Application No: EP/58/21/HH
Site Address: Mistibeech 15 Tamarisk Way East Preston BN16 2TF
Description of works: Erection of part single, part two storey rear extension with roof terrace, garden outbuilding in rear and detached garage to front following the demolition of existing sun room and roof terraces

This council's Planning & Licensing Committee considered this Application at its meeting on Monday, 28th June.

Client: Mr & Mrs Rabson	
Project Address: Mistibeech 15 Tamarisk Way East Preston	
Drawing Title: Proposed Garden Room and Garage Plans, Elevations, Roof Plans and Site Block Plan	
Drawing Number: 1314.03.c	
Scale:	As stated printed @ A1
Date:	20/05/2021

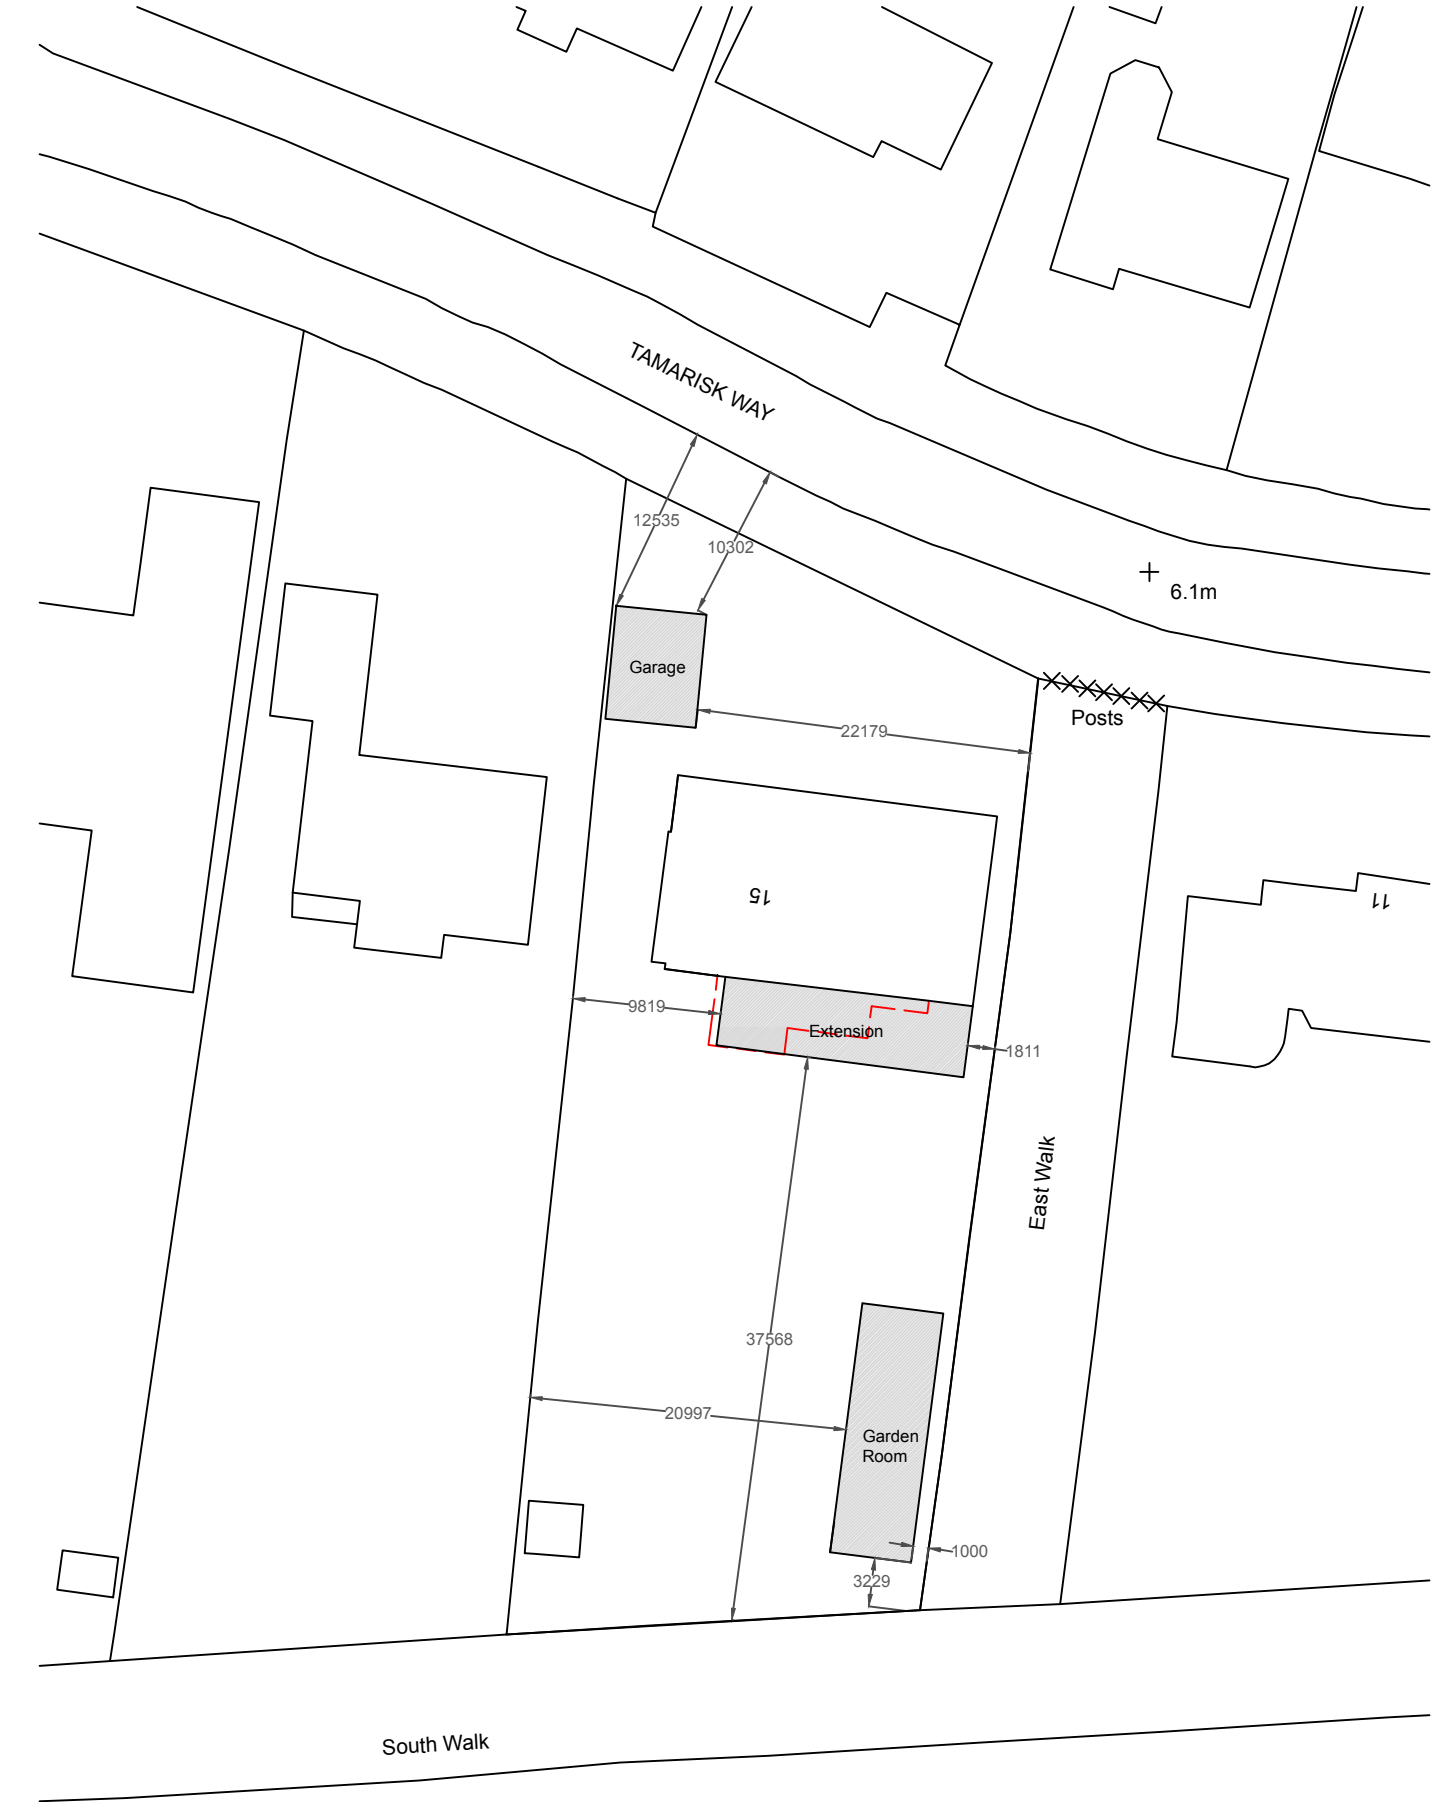
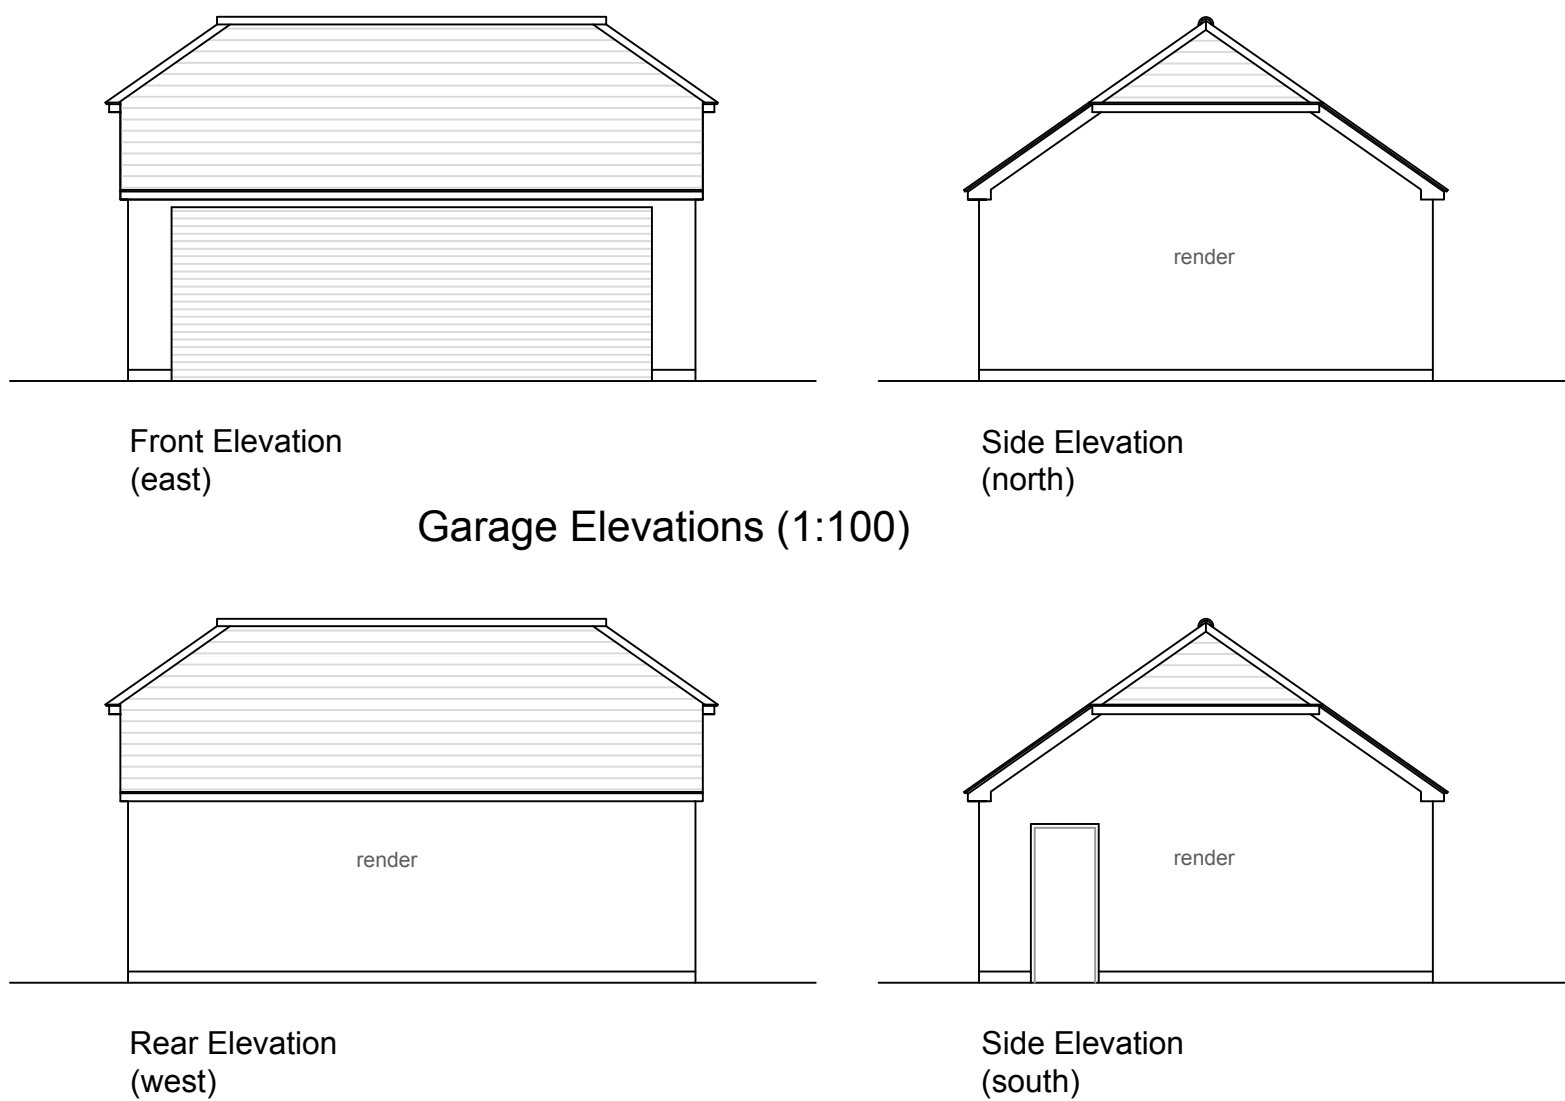
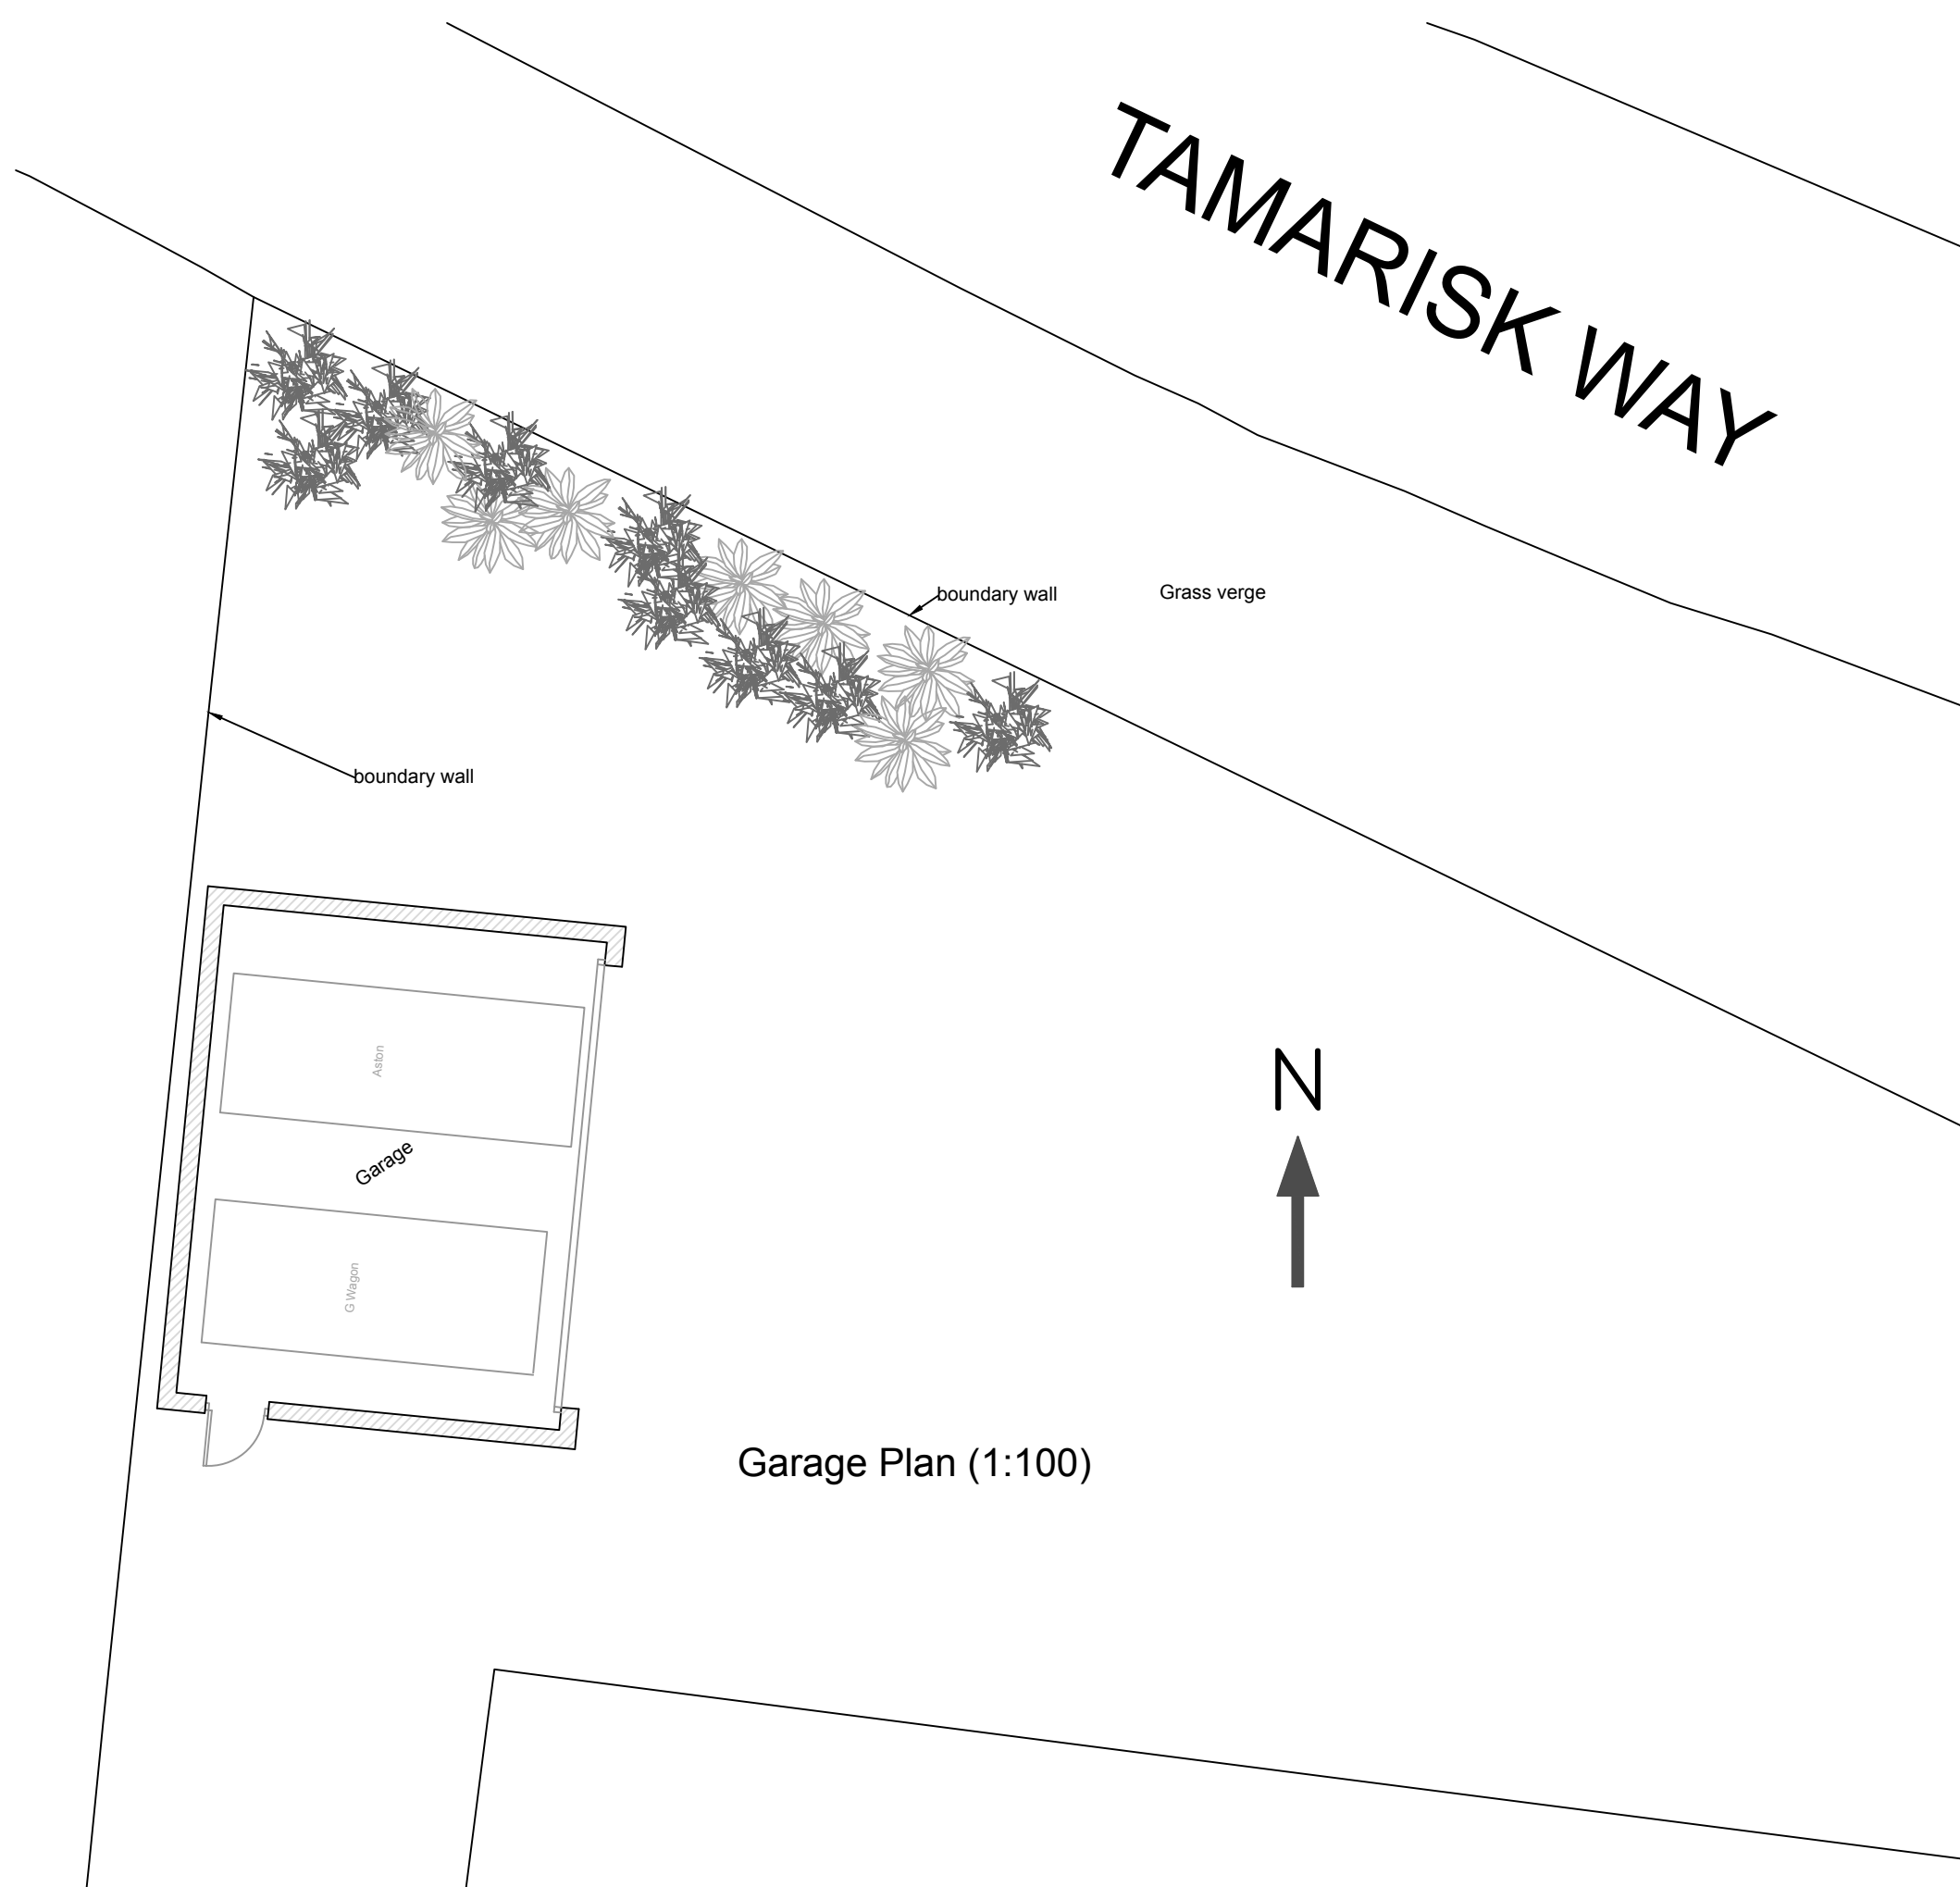
The proposed garage is set too far forward on the plot and would have an unacceptable impact upon the streetscene.

As no proposed North elevation has been provided, the committee has been unable to consider the impact the proposed garage will have upon the look of the building itself. However, the committee felt the proposed garage was likely too far from the existing building to integrate visually with it. We believe this to be in conflict with policies D DM1 and D DM4 of the Arun Local Plan and the East Preston Neighbourhood Plan.
